From: Liz Annalls [REDACTED]
Sent: 07 December 2020 10:37
To: Planning.Responses <Planning.Responses@arun.gov.uk>
Subject: RE: Planning Consultation on: WA/93/20/PL

App No: WA/93/20/PL
Address: Tye Lane Walburton BN18 0LU
Proposal: Alternative access & emergency access along with minor highway works following WA/95/18/RES. This site is in CIL Zone 2 (Zero Rated) as other development.

Drawing Title:
**PROPOSED ACCESS IMPROVEMENTS
- TYE LANE/AVISFORD PARK ROAD**

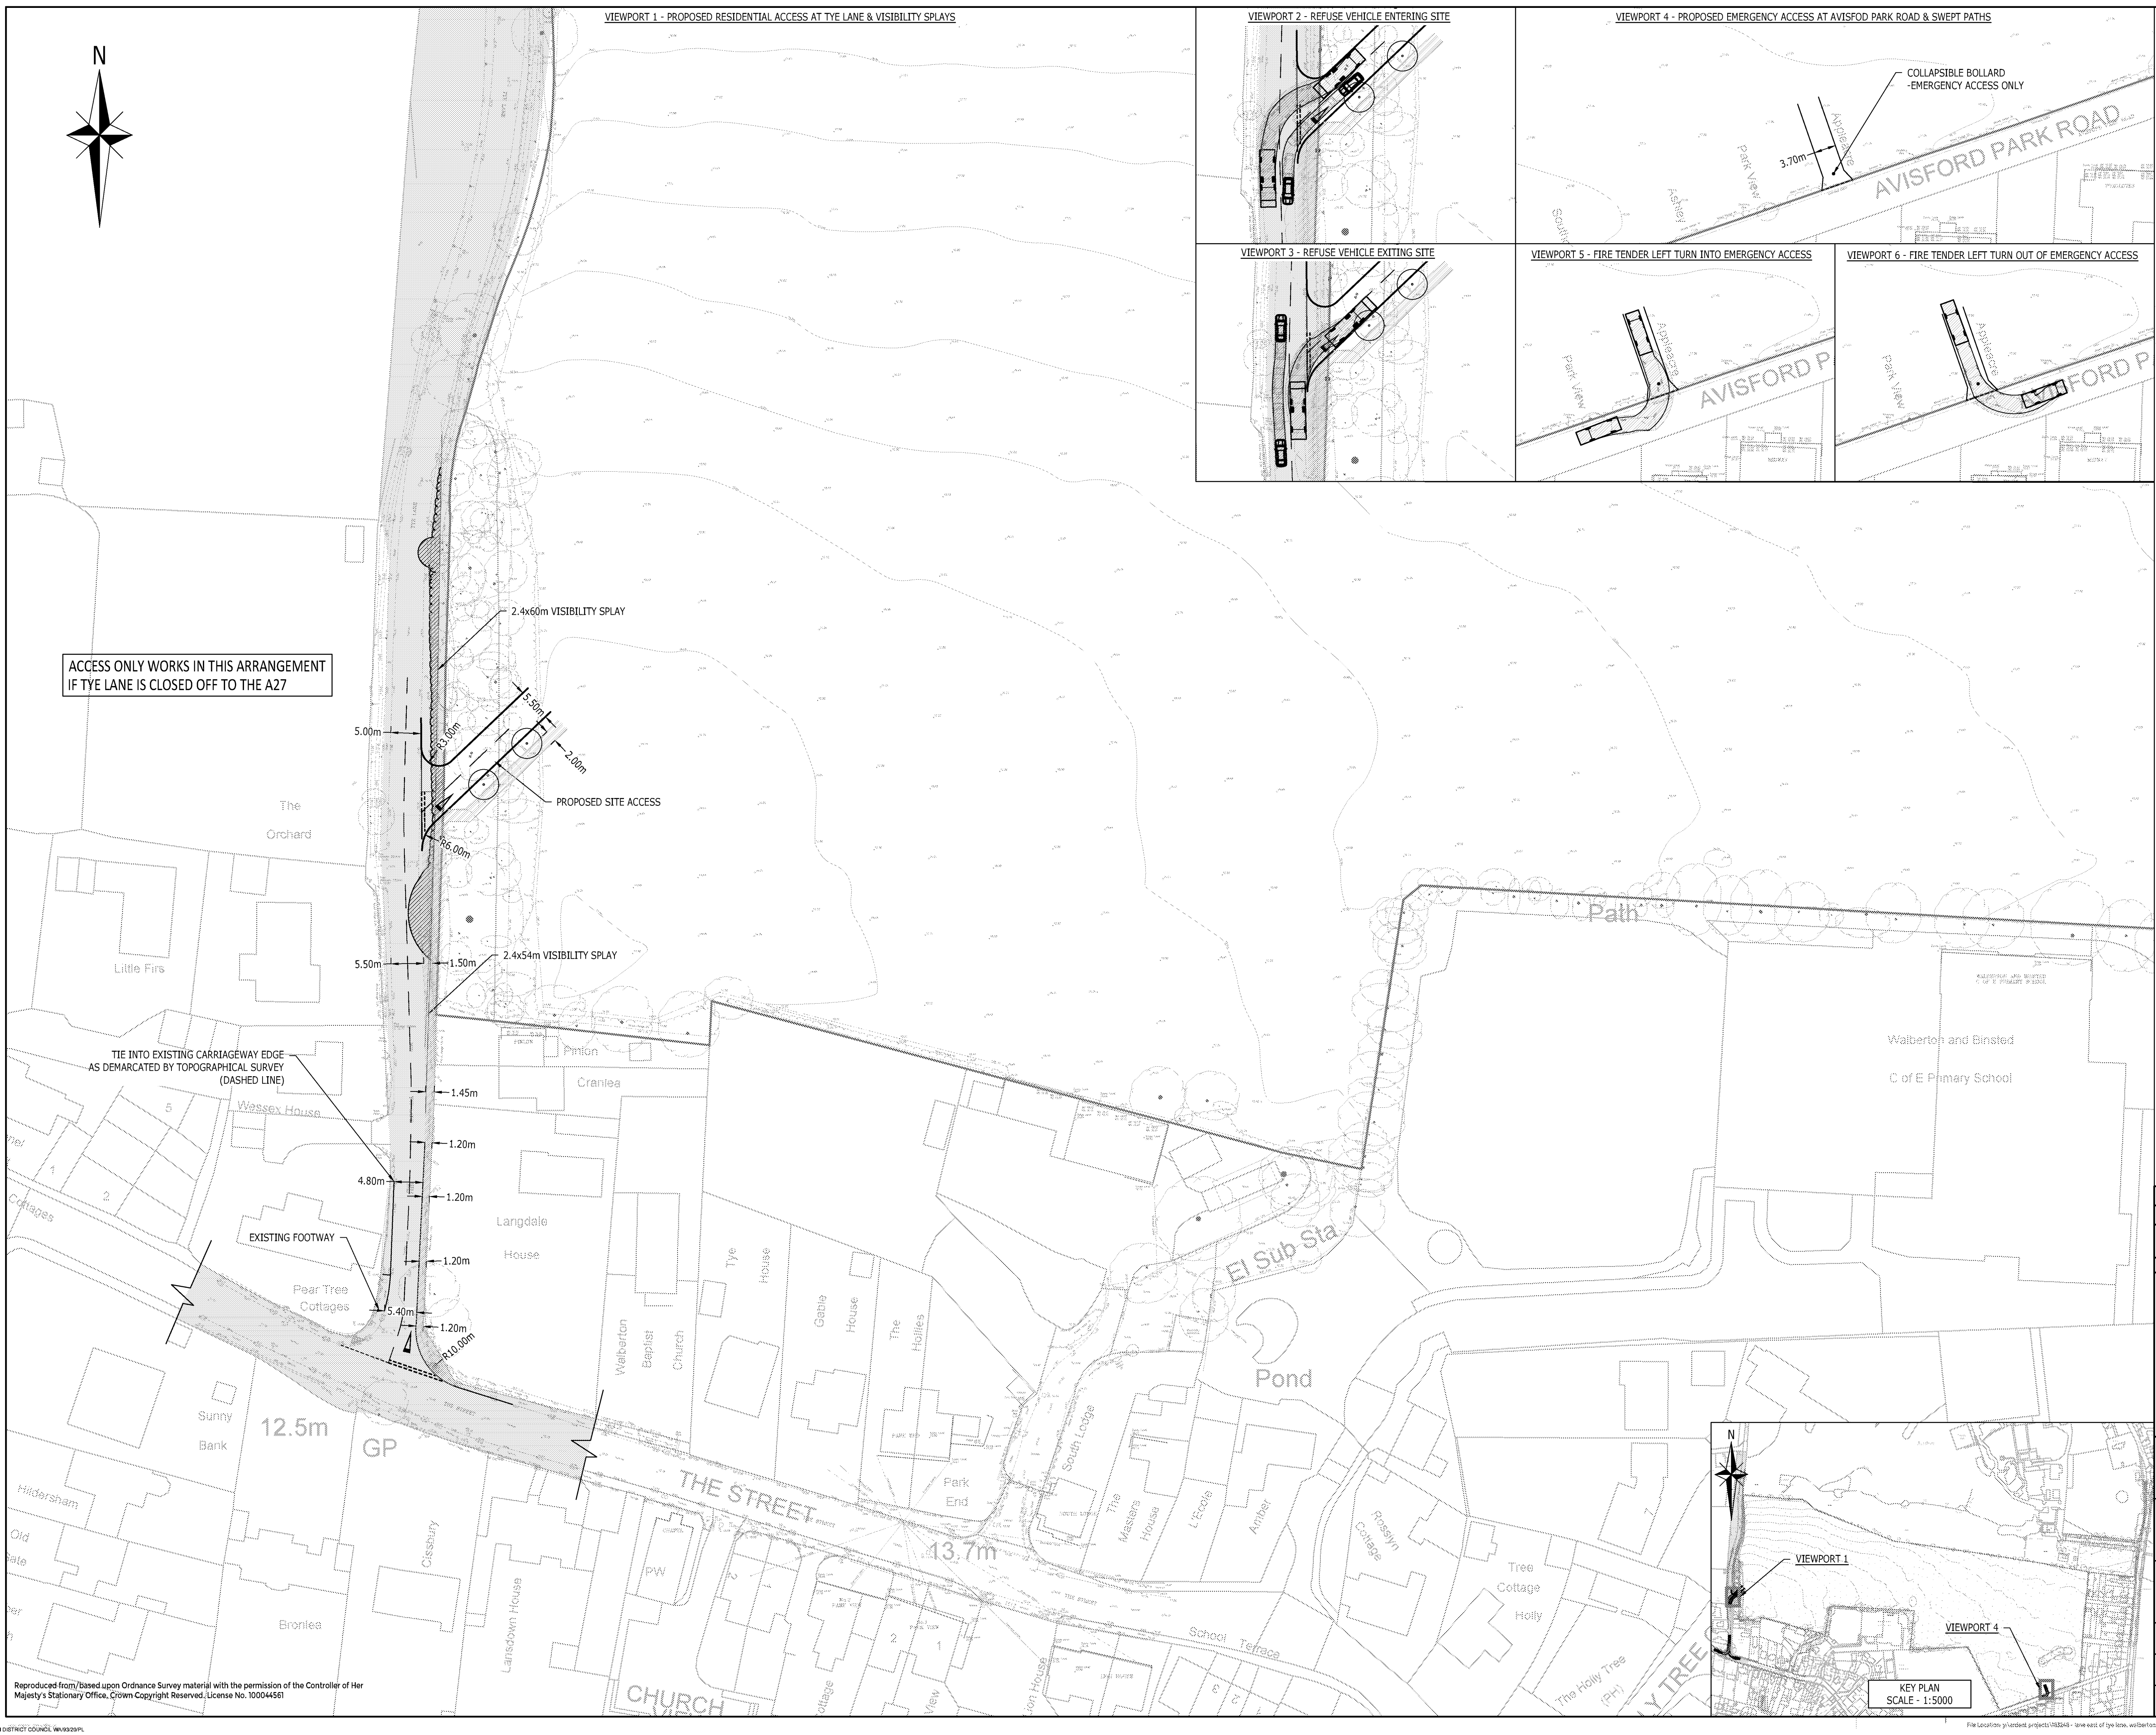
Due to the proposal to amend the access onto this site, there is likely to be an impact on an area of hedgerow / treeline online the site boundary. Please can an assessment be done by the site ecologist to determine any impact this may have on habitats and protected species on site and provide mitigation for this.
